23 October 2020

Reference: 0418291

Subject: Sancrox Quarry Response to Submissions

Table 6.1 *Conceptual Basin Sizing*

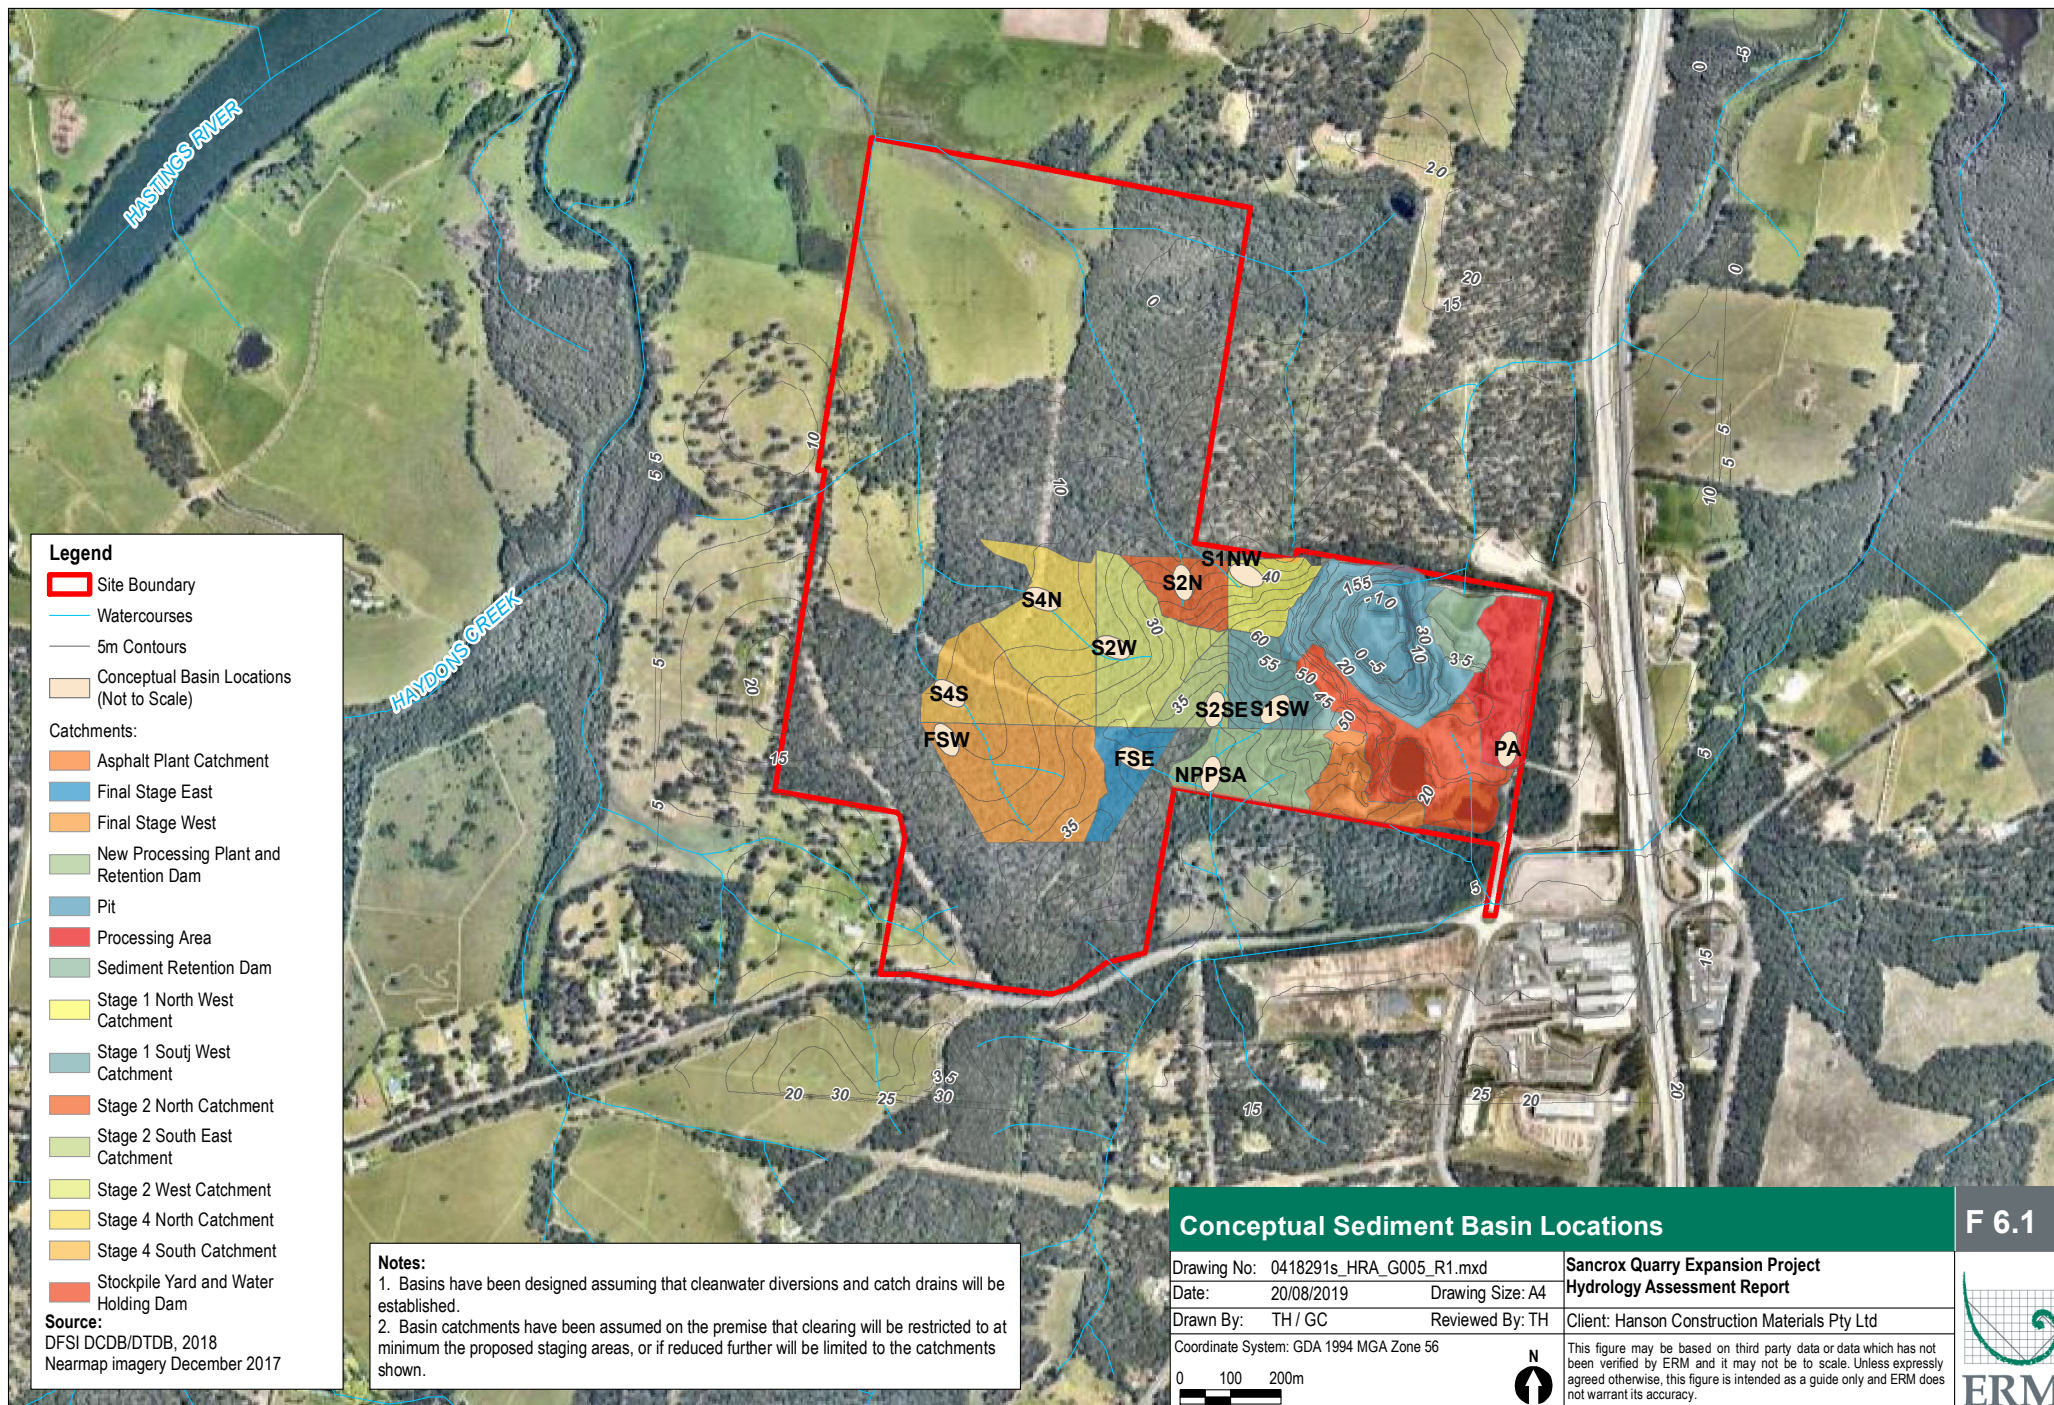
Submission Reference No.	Submission	Response
Soils and Water		
EPA #24	<p>Soil Properties</p> <p>Revision of the need to extend the development and sediment basins into the very strong acidity Euroka Soil Landscape.</p> <p>Alternatively, provide a more detailed assessment of the potential impacts and mitigation measures addressing the potential risk to water quality.</p>	<p>The site is mapped as comprising three soil landscapes; Kundabung, Cooperabung and Euroka. The quarry extension is predominately across the Cooperabung soil landscape. The revised quarry plan provided with this RtS has straightened and moved the western quarry boundary eastward out of the Kundabung soil landscape and slightly reducing the impact on the Euroka soil landscape. The Euroka soil landscape is mapped across extensive areas from north of Kempsey to south of Wauchope and generally west of the Pacific Highway.</p> <p>The EIS at Section 9.3.2 provides a general description and limitations of the Euroka soil landscape including having very strong acidity. Atkinson (1999) confirms that the very strong acid soils are in the range pH 4.5-5.5 in the B and C subsoil horizons to a depth of approximately 100-120 cm depending on depth of the topsoil. The acidity limitation relates to agricultural use in which liming to increase pH to above 5.5 is recommended to improve agricultural productivity. Interrogation of the eSPADE data for NSW (OEH, 2012), provides a soil profile report at a location on Sancrox Road approximately 500 m south west of the revised quarry footprint. The soil profile report confirms the soils in this locality have A-horizon to a depth of 35 cm and B-horizon to 120 cm. The report confirms a field pH of the A horizon at pH 6.0 and subsoils at pH 5.0-5.5, a higher pH range than noted in the general description and limitations of the Euroka soil landscapes.</p> <p>The quarry void is not self-draining and runoff is collected in a sump which is pumped to the onsite dams for reuse for product moisture, dust control and rehabilitation works or eventual discharge offsite within pH criteria under an existing Environment Protection Licence (EPL). Runoff from surrounding disturbed areas including the office and processing areas drain to the onsite dams. This process will continue for the proposed quarry expansion.</p> <p>Overburden including topsoil will be separated and stockpiled for future reuse. The stockpiles will be stabilised and located within the disturbance footprint such that runoff will be directed to the onsite dams. The overburden stockpiles will constitute a minor portion of the total catchment areas for the onsite dams. Given the quarry is subject to water discharge limits under the EPL, and it is expected that these limits will remain for future quarry activity, management of pH in discharge water is through monitoring and pH adjustment as required.</p> <p>Given the strong acidity of the Euroka Soil Landscape, soil sampling will determine if required adjustment of pH using a determined lime application rate during stockpiling.</p> <p>Water quality testing of the most downstream onsite dam will determine compliance, and identify if pH modification (through use of products such as lime or hydrochloric acid) or total suspended solids modification (through the use of gypsum) is required prior to discharge.</p> <p>In summary management of highly acid soils will be through separation and placement in stabilised overburden stockpiles for future reuse and rehabilitation of the quarry. The stockpiles will be located within disturbed areas of the quarry which drain to the site's large capacity dams. Collected runoff is prioritised for onsite reuse and any discharges offsite are subject to EPL conditions including pH criteria. Therefore, the potential impacts will be managed through the implementation of appropriate mitigation and management which will be outlined in a Soil and Water Management Plan (SWMP).</p>
